From: Simon Davis
Sent: 20 May 2019 16:14
To: Planning Scanning
Subject: FW: Y/9818/RES and Y/97/18/DOC

Application Correspondence label as "Response to Drainage Engineer"

Still not happy with the details or the proposed landscaping details. My original comments are shown in blue, the applicants responses are provided in red, and my responses to these are shown in purple:

Comments on the revised drainage and landscape proposals:

BOVIS HOMES
scheme: Land off Burndell Road Yapton
client: Bovis Homes
drawing: Hard Landscape Proposals
date: Nov. 2018
scale: 1:200@A1
drawing no: BOV22172 12E sheet 4
drawn: AE checked: DKM

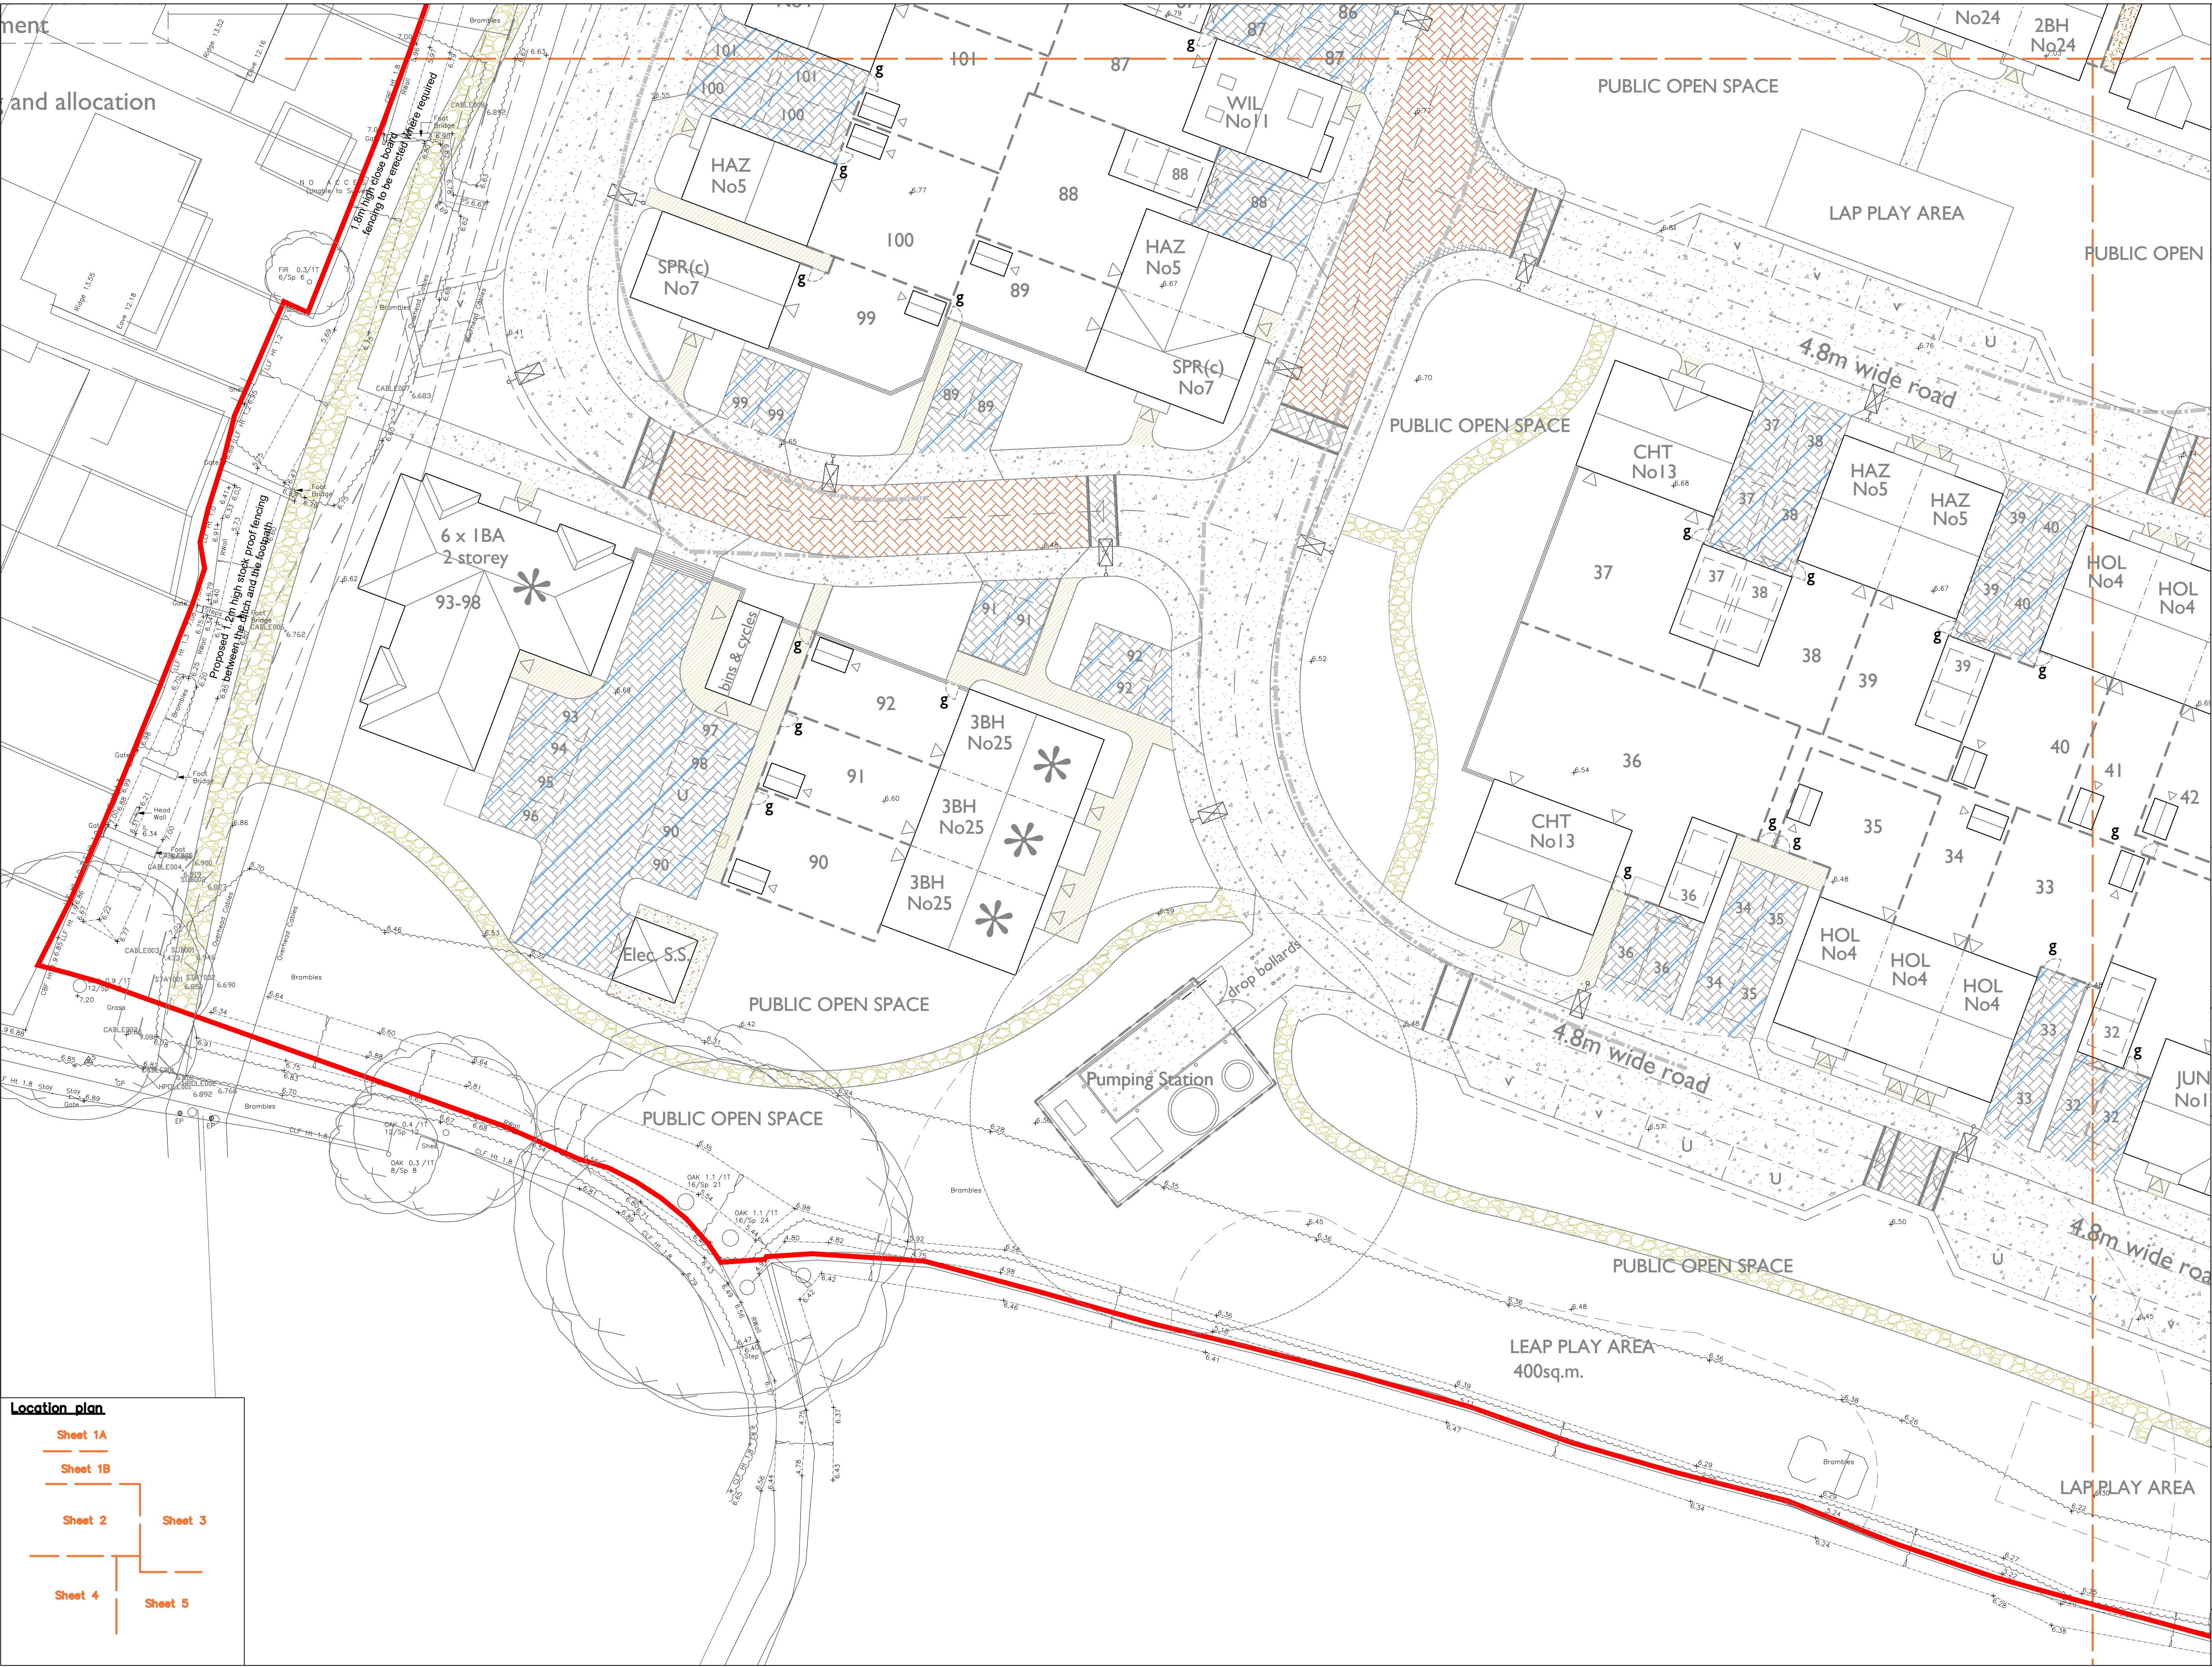
1. There are still trees proposed in close proximity to the southern-most attenuation tank. 2 no. trees close to this tank have been removed. Refer to updated ACD landscaping drawings. *On the ACD landscape drawing sheet 4 revision G there are trees in close proximity to the crate nearest the pumping station. Please can a plan be provided which shows both the proposed drainage and the proposed planting and associated potential root areas on the same drawing.*

1. ACD have shown tank footprints on their landscaping plans. Updated plans provided.
2. Pond sections with NAUE liner provided. Details provided. Tank flotation/groundwater assessment to be discussed as soon as possible.

Job Title		
LAND SOUTH OF BURNDELL ROAD, YAPTON		
Drawing Title		
PRIVATE DRAINAGE CONSTRUCTION DETAILS SHEET 1 OF 2		
Client		
BOVIS HOMES		
Scale	Date	Designed
NTS @ A1	APR 19	SG
Drawn	Checked	Approved
TSB	SG	LH
Job No	Drawing No	Rev
18-070	18-070/110	C

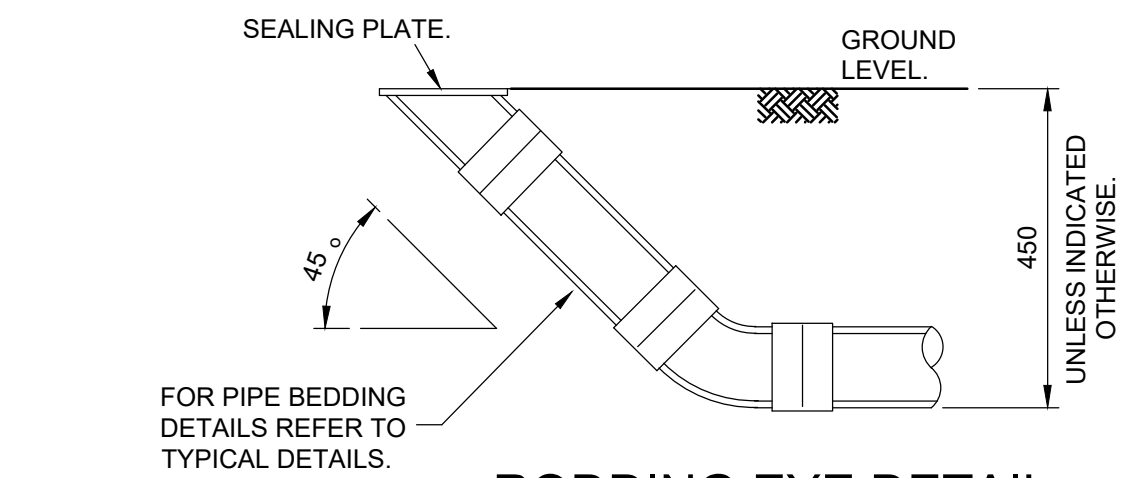
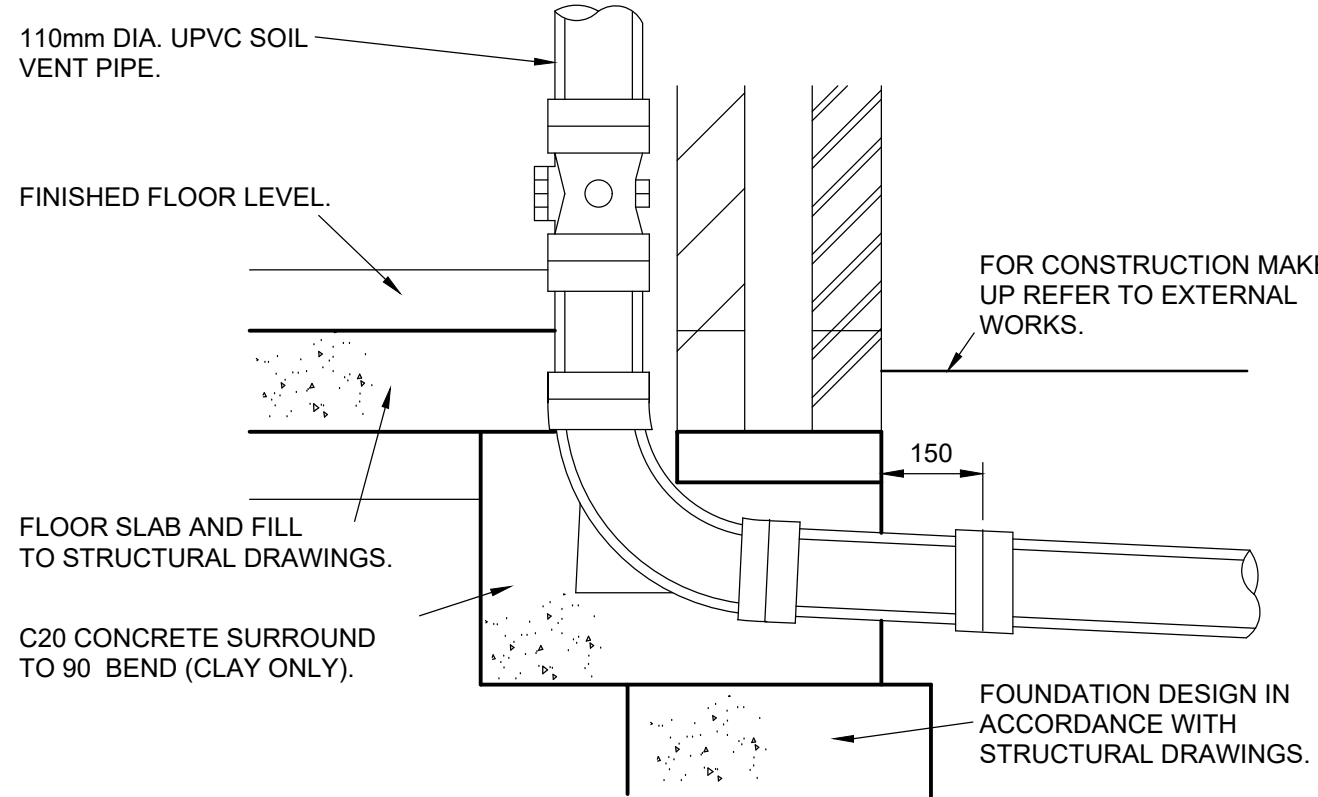
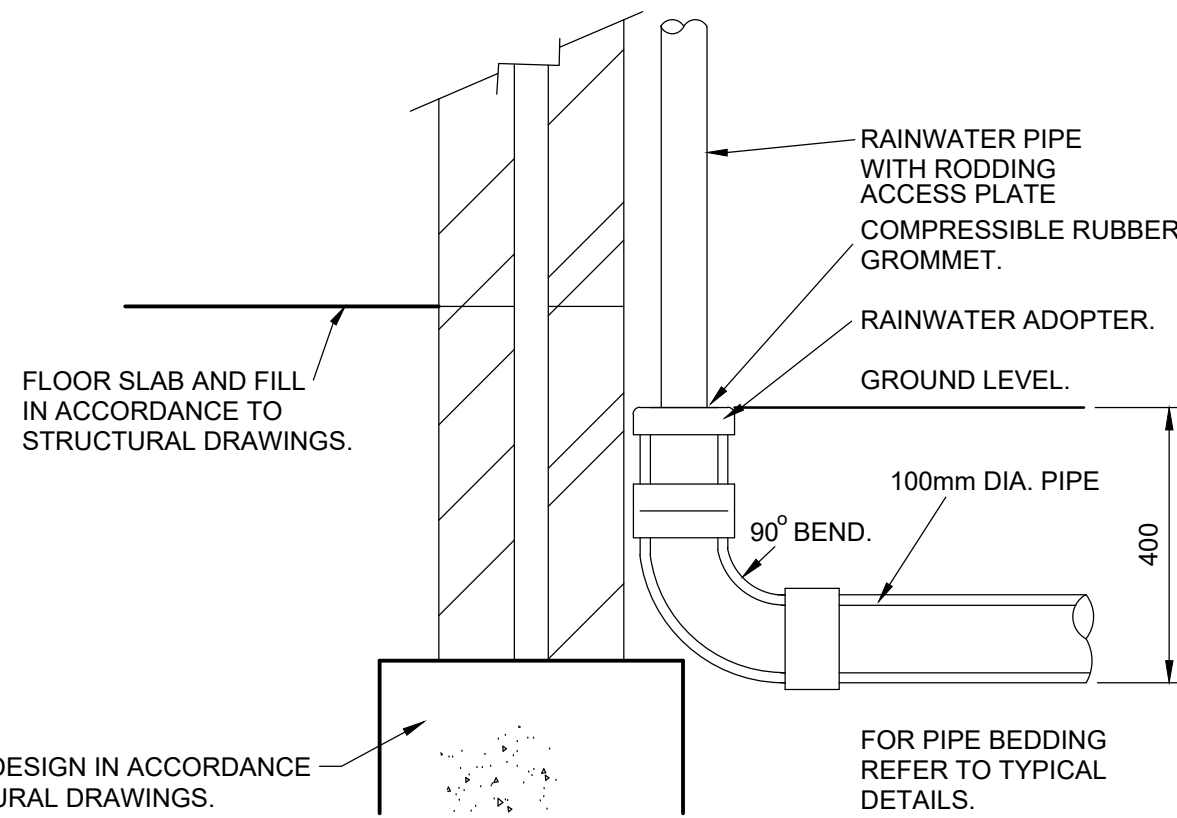
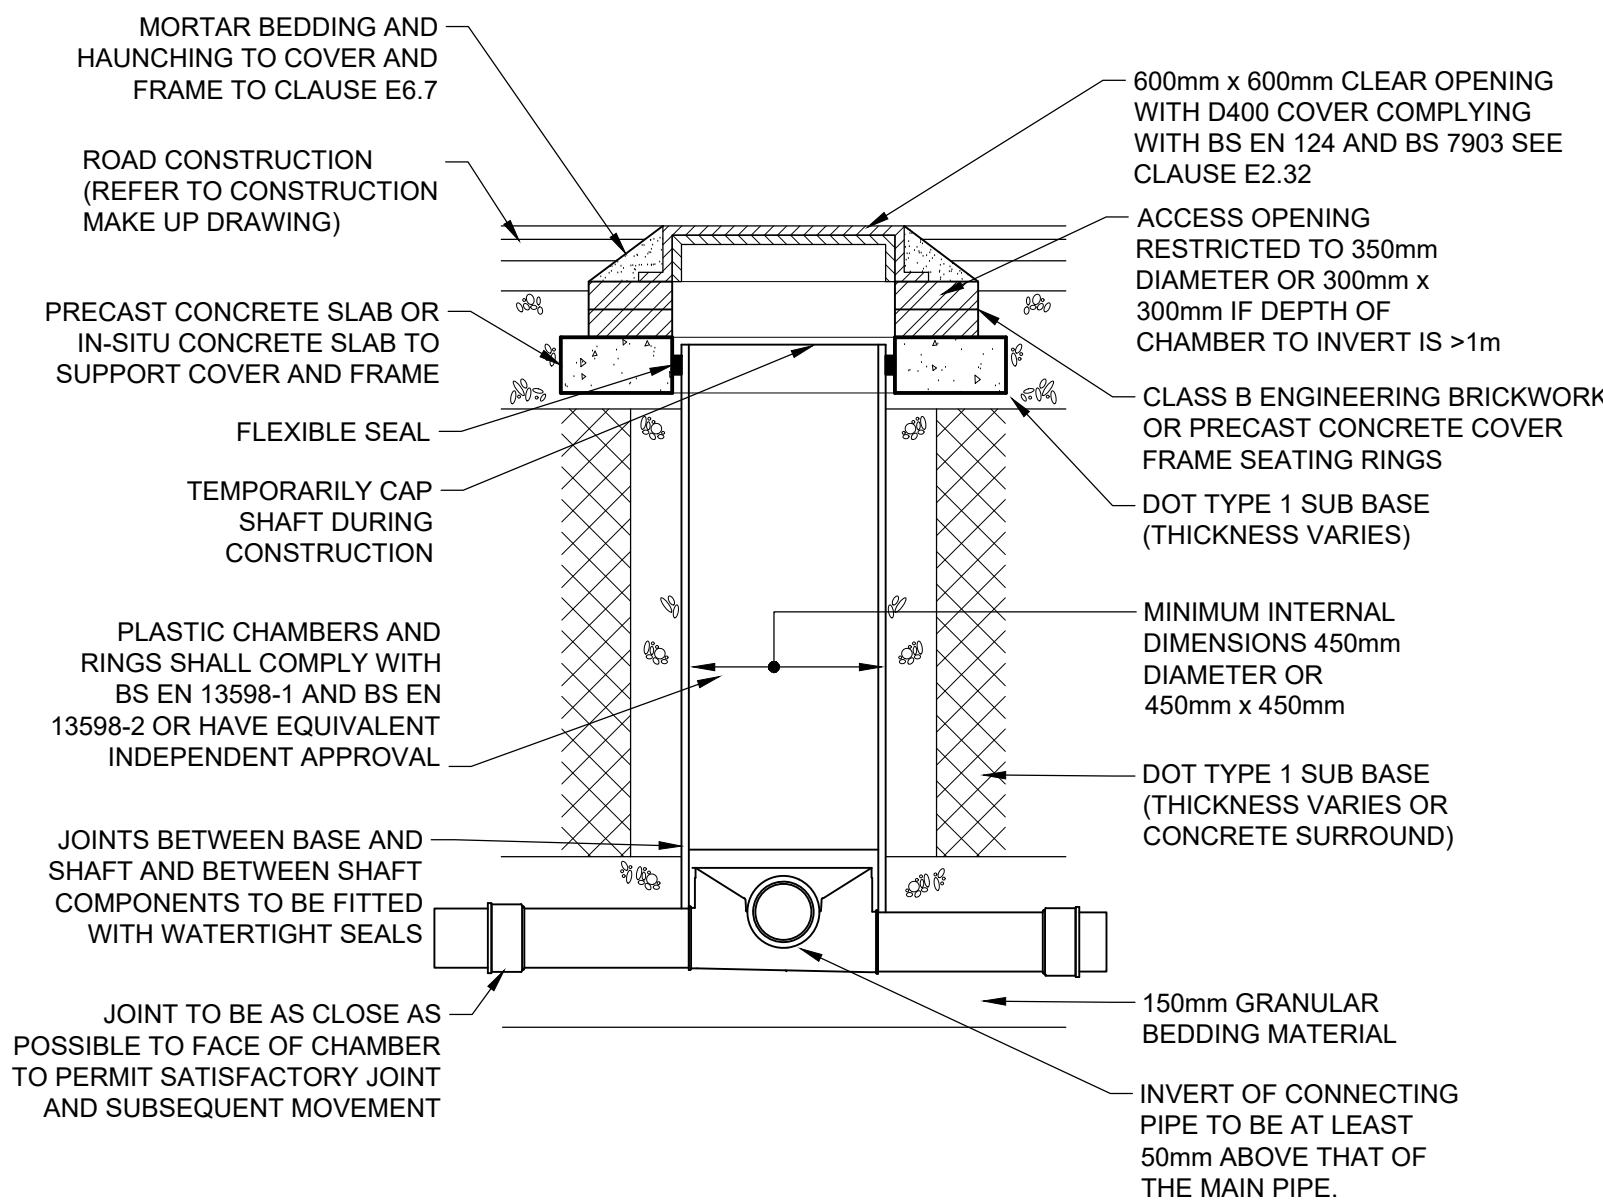
- a. *Construction detail drawings have been provided of diffuser units stating inlet from house, is this what is proposed? It isn't actually clear from the layouts if standard rwp connecting to the main piped network are proposed. There certainly are no diffuser units shown on layouts.*

5. Drainage drawing shows smaller basin (as mentioned recently) and all associated basin levels. Refer to updated plan provided.
6. Standard detail updated to show diffuser and control chamber together. Plan updated to show incoming surface water diffusers for typical drive. Permeable paving depths added to drawing (notes). Refer updated plans provided.
